22 March 2022

## **Exhibition of State Significant Development Application Lang Walker AO Medical Research Building – Macarthur Application No SSD-17491477**

Figure 4 Proposed location of bin store and collection point

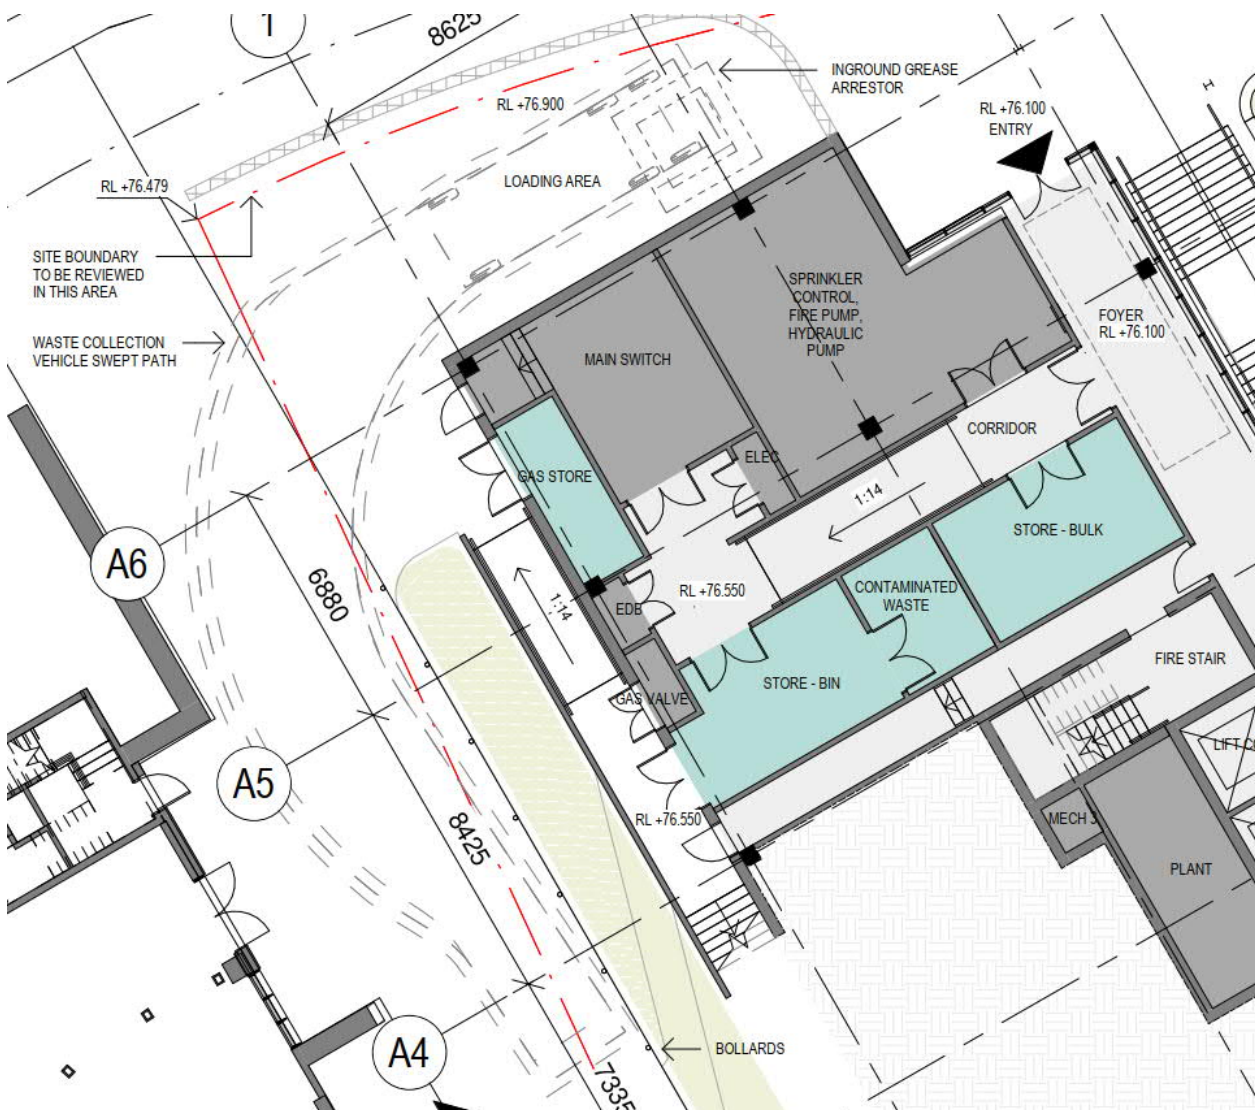
C. "From a traffic management perspective, additional driveway access from Parkside Crescent should be avoided, as this would result in reduced on-street car parking, and would negatively impact on the safety of all road users. As stated above, the opportunity for the loading bay to be accessed from within the hospital site should be pursued."

Response: Additional driveway access from Parkside Crescent is not required as waste is to be collected from the site via the service area located on the south western corner of the site with access to this area via an existing vehicular crossover which exists for the MSV building to the south of the site.

Additionally, the loading bay will be accessed from the same, existing vehicular crossover.
